EL PASO COUNTY

DEPARTMENT OF PARKS AND COMMUNITY SERVICES

November 3, 2023

Subject: Mayberry Sketch Plan, Preliminary Comments (SKP236)

Regional Trail

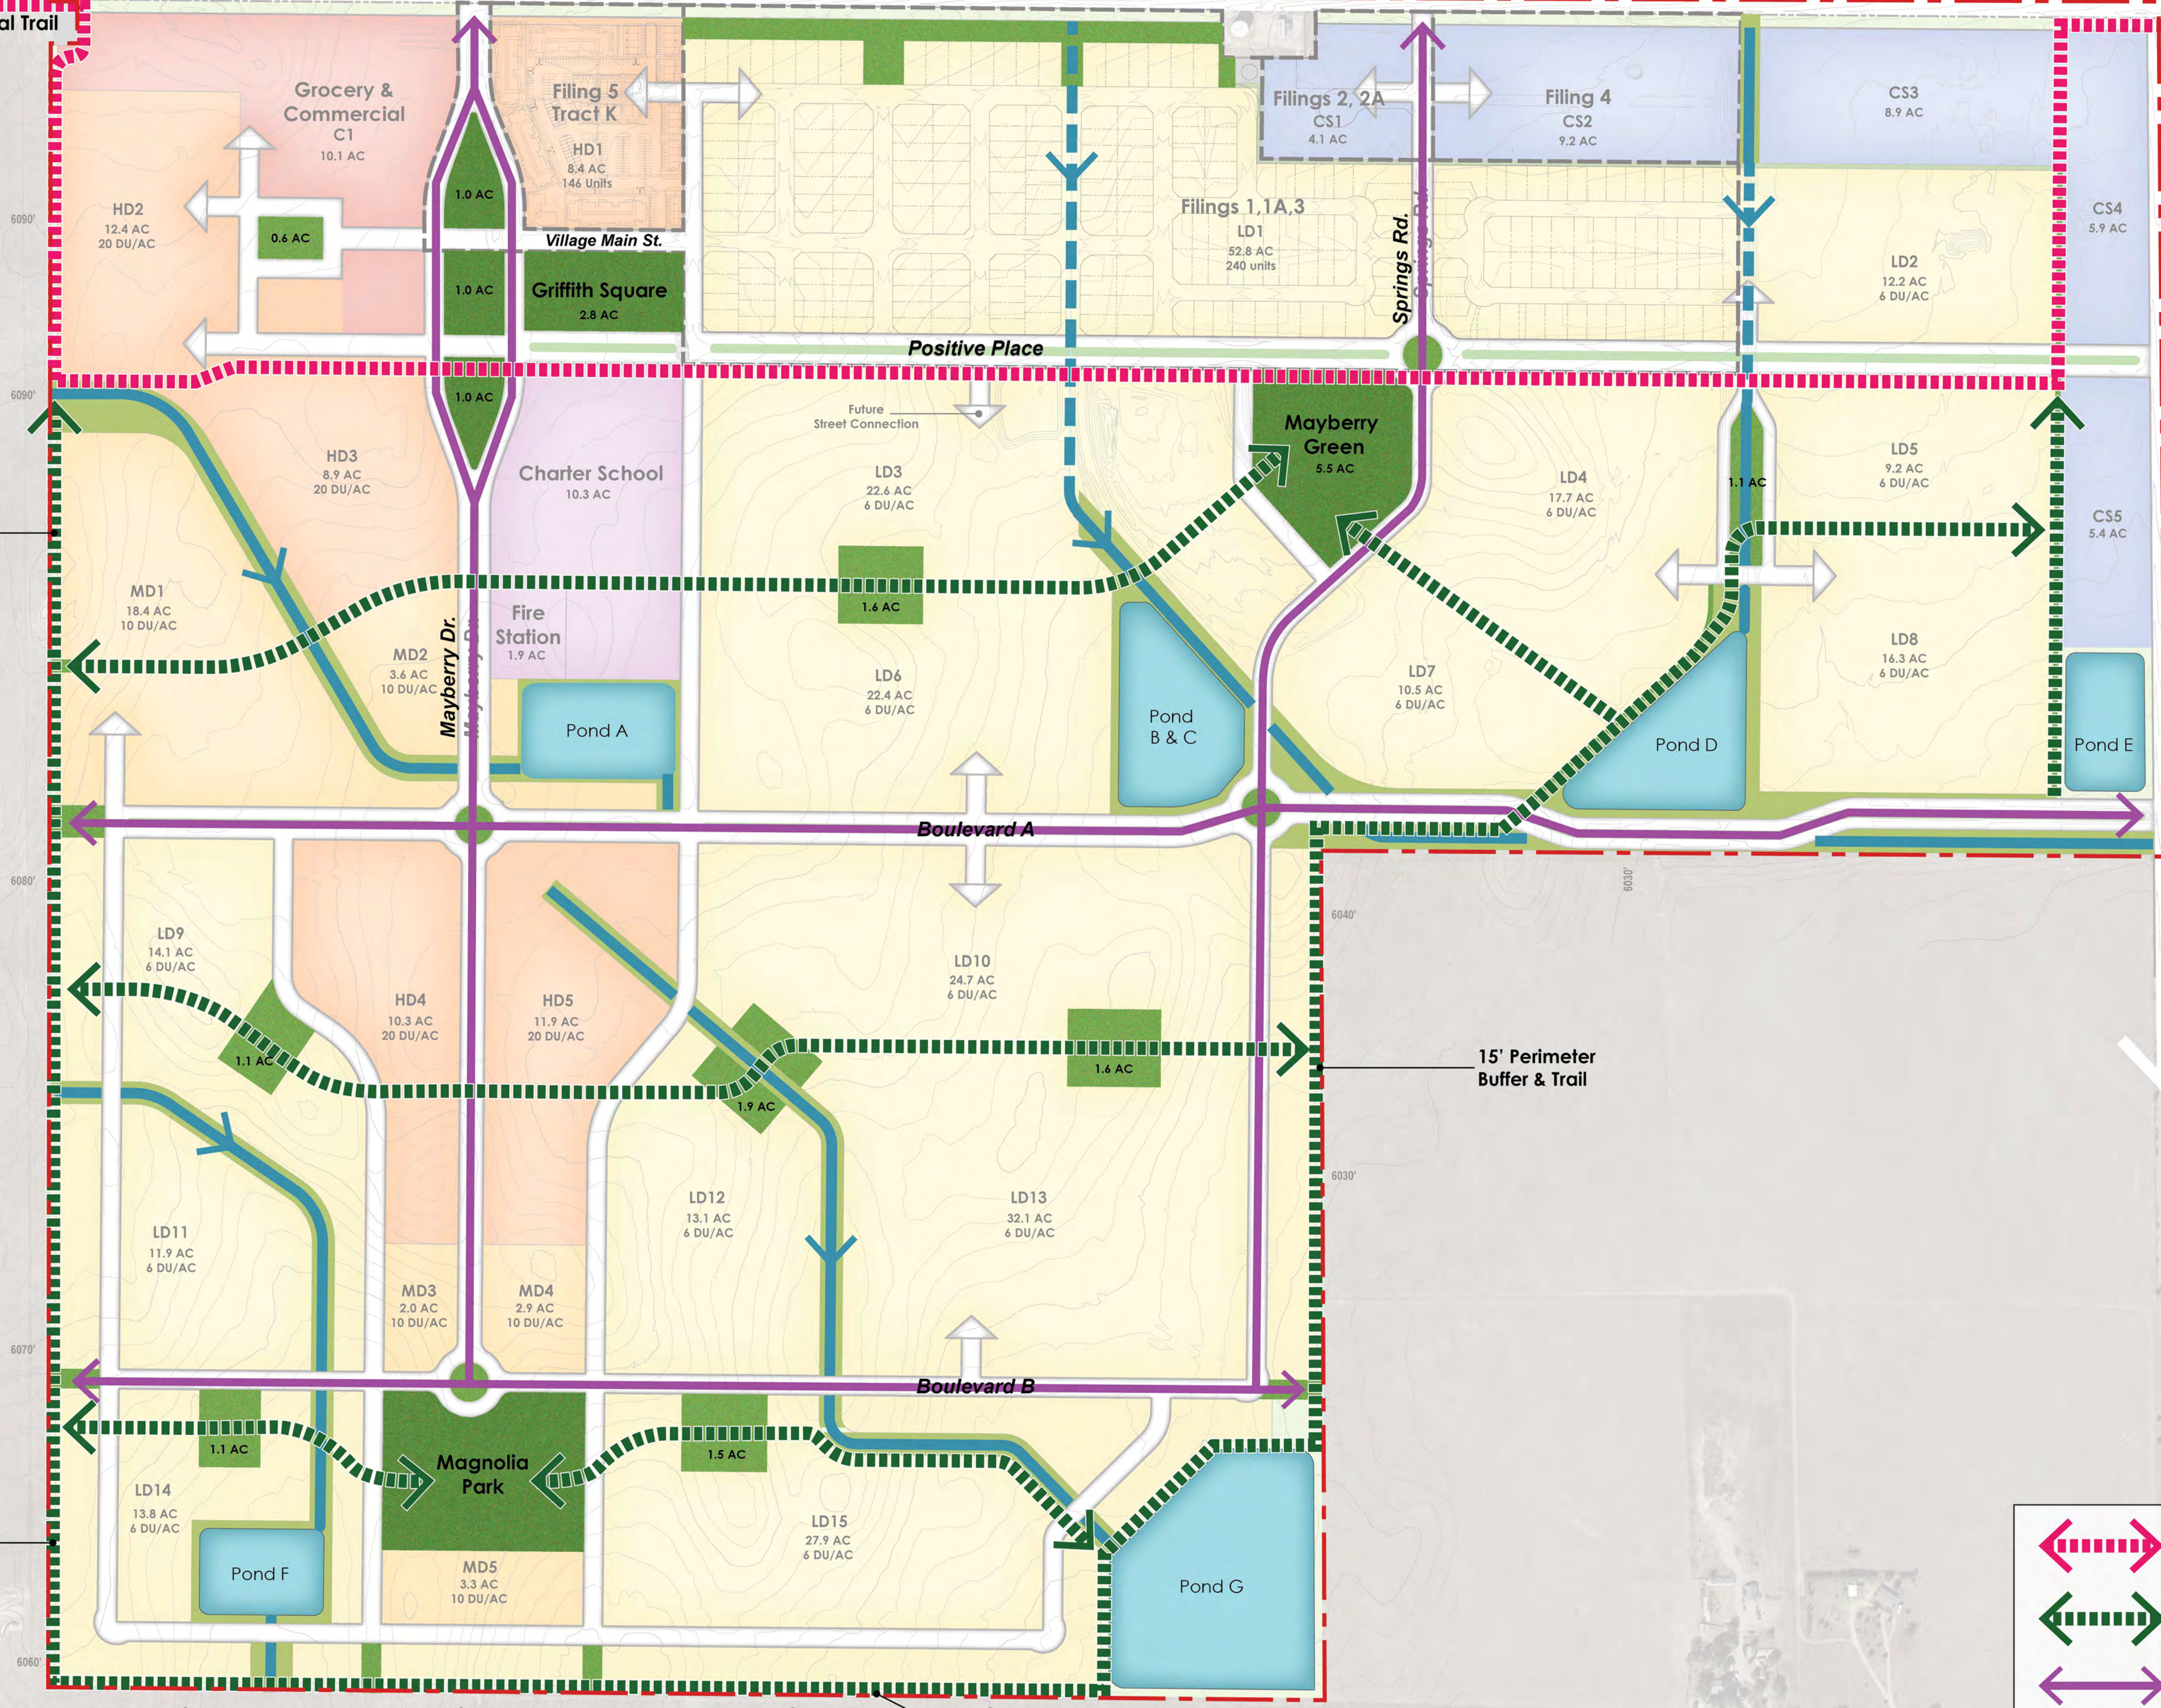
The Highway 94 Regional Trail easement has previously been recorded as a trail easement to El Paso County on Mayberry Filings 1-4. The 25' wide trail easement is on the south side of Highway 94 on the previously dedicated easements. The current sketch plan shows a 'Regional Trail' following the Highway 94 at each end of the proposed development, then going south approximately 1,100' before turning into an east-west trail. The Highway 94 Primary Regional Trail is a trail that will connect Ellicott, CO to Colorado Springs, CO and will be 10 miles long when completed. As a regional trail connecting communities, it will not have tangents and instead will have a straight alignment following the southside of Highway 94. The regional trail needs to be adjusted closer to the mater-planned trail alignment.

El Paso County Parks recommends that the applicant designate and provide to El Paso County a 25-foot trail easement along the south side of Highway 94 that allows for public access, as well as construction and maintenance by El Paso County of the Highway 94 Primary Regional Trail, and show the easement on the forthcoming Preliminary Plan and Final Plat(s), and dedicate the aforementioned easement to El Paso County prior to the recording of the Final Plat(s).
